# **KITTITAS COUNTY**

### **County Survey review of Boundary Line Adjustment 15-00017**

PART OF THE NORTHWEST QUARTER OF SECTION 34,
TOWNSHIP 19 NORTH, RANGE 18 EAST, W.M.

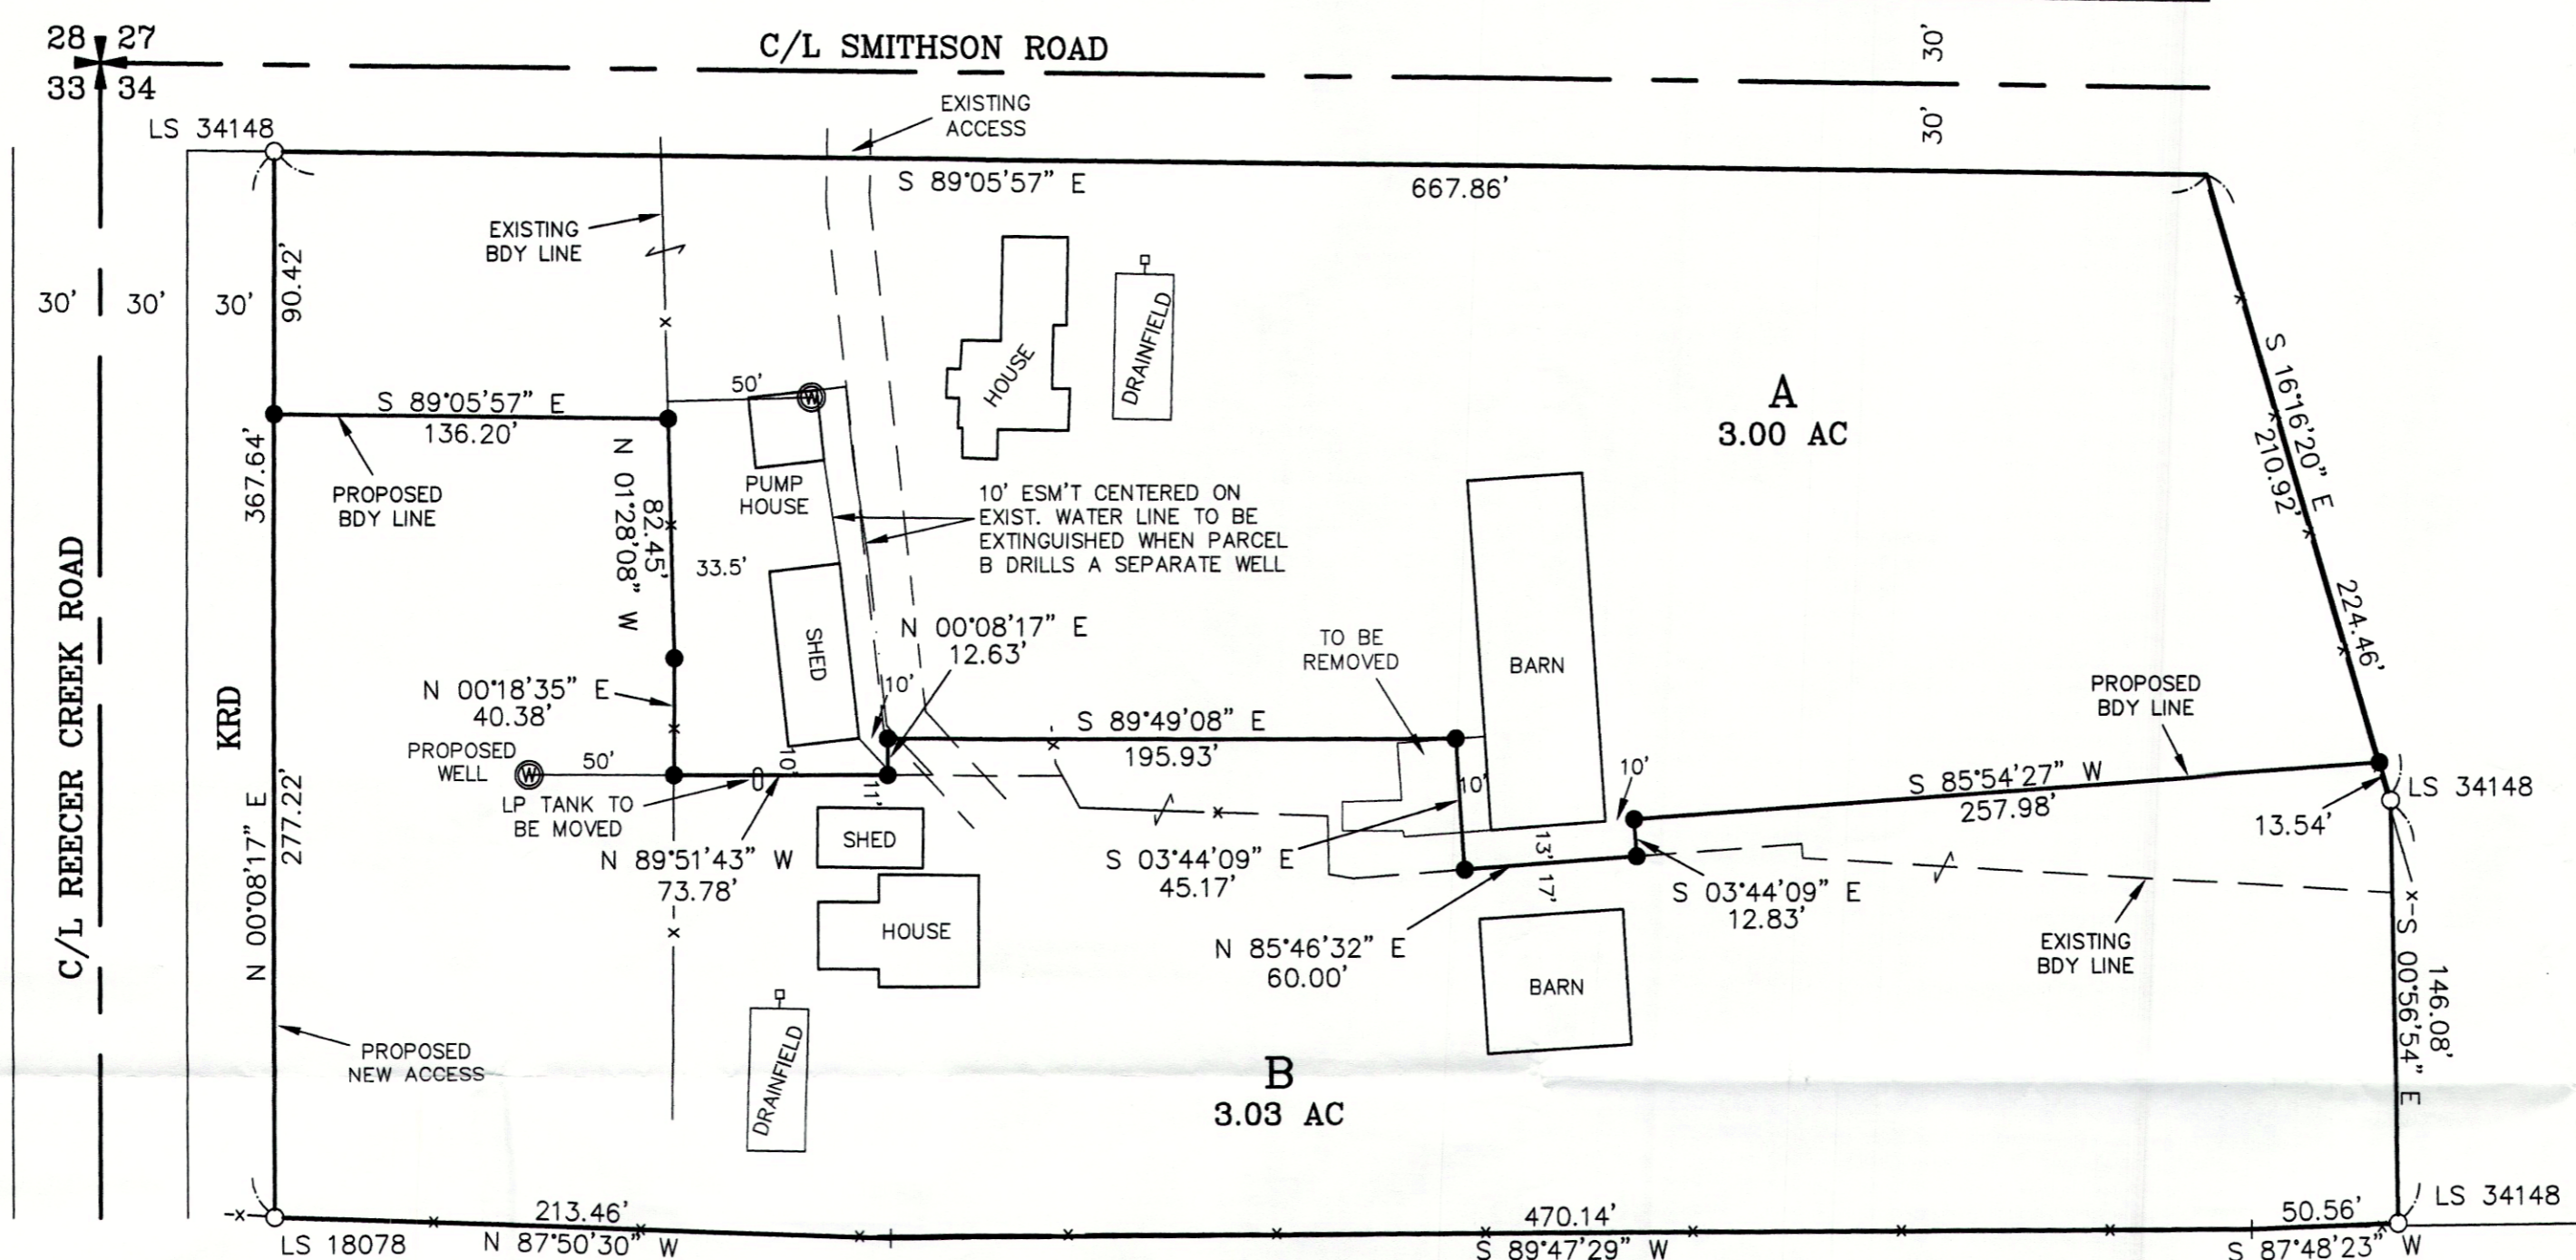
1. Under Notes, the basis of bearing needs to be changed to reference the actually line, not an entire recorded document. The only line I have found that matches the referenced document is shown as S00-56-54E, 146.08'. Alternatively, it would be fine to use the following statement: "The basis of bearing is the N line of the NW quarter of Section 34, taken to be S89-05-57E for the purpose of this survey."
2. Please show a note referencing what was found at the NW section corner, or add a note stating that is was not searched for/found.
3. The new parcel descriptions should probably be changed to reflect a filing date that is not February.
4. The proposed new access for Parcel B is onto KRD lands, not a public R/W. In the KRD comments, nothing additional was required, but I would like to confirm with KRD. I have contacted them and am awaiting their response.
